From: Rita Williams [REDACTED]
Sent: 10 August 2018 14:36
To: Planning; Michael Eastham
Cc: Cllr. Dudley Wensley; Cllr. Andy Cooper; Cllr. Paul Bicknell; 'Deborah Urquhart'
Subject: A/99/17/OUT - Landscape impact land South of Water Lane

Landscape Impact and Mitigation

Plan illustrating Proposed Landscape Strategy
produced by David Jarvis, 2016. NTS.

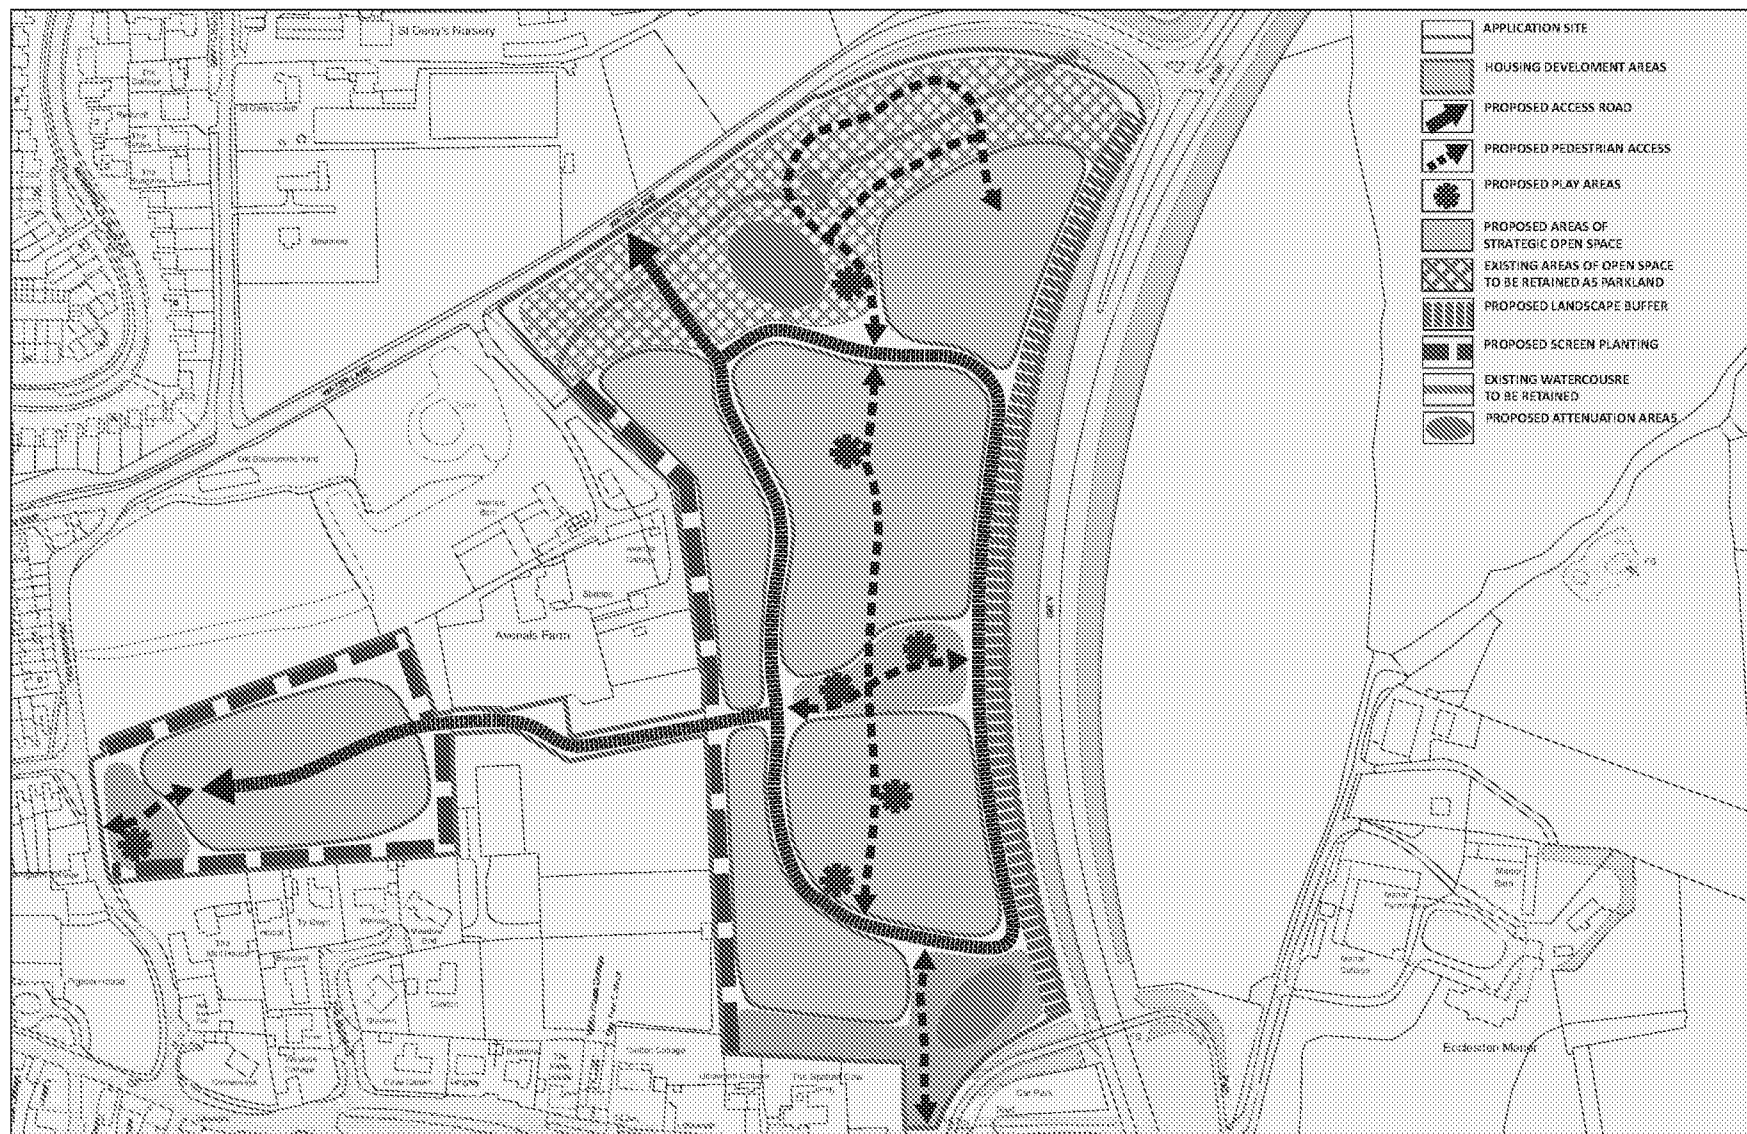
Arun has suggested *"an additional 5.0 metre deep extension to the proposed landscape buffer along the eastern boundary of the site would mitigate the visual impact of the residential development and ensure that the current outline planning application accords with the NPPF, Policy GEN7 of the Local Plan, Policy HD5 (Built Form) of the Neighbourhood Plan and Policy LAN DM1 of the modified eALP."* This would increase the depth of the landscape buffer planting from **5.5m to 9m to 10.5m to 14m.**

However, the applicant remains adamant that: *"From the photomontages and observations on site it is concluded that the thickening of the buffer by 5m along its entirety would not provide any additional screening of consequence. The buffer is sufficiently thick to provide the screening required in the LVIA and to address the Inspector's concerns."*

Assuming this *"belt of woodland"* reflects trees in the surrounding landscape (beech, ash, evergreen oak etc.) retaining the proposed **5m to 9m strip** is clearly not sufficient to allow these woodland trees reach maturity or to address issues of shading, the temptation to prune back branches, leaf fall etc.

The LVIA fails to provide any evidence that the impact of the height and density of the development would be mitigated by the proposed landscape buffer and that *"Any views of the site from the South Downs National Park would be limited to those areas east of the site and would be limited to glimpses of roofs over the existing vegetation"*. This clearly remains an assumption on the applicants part, as does the mitigation to limit any adverse impact on the national park's designation as an International Dark Sky Reserve (**Policy QE DM2**).
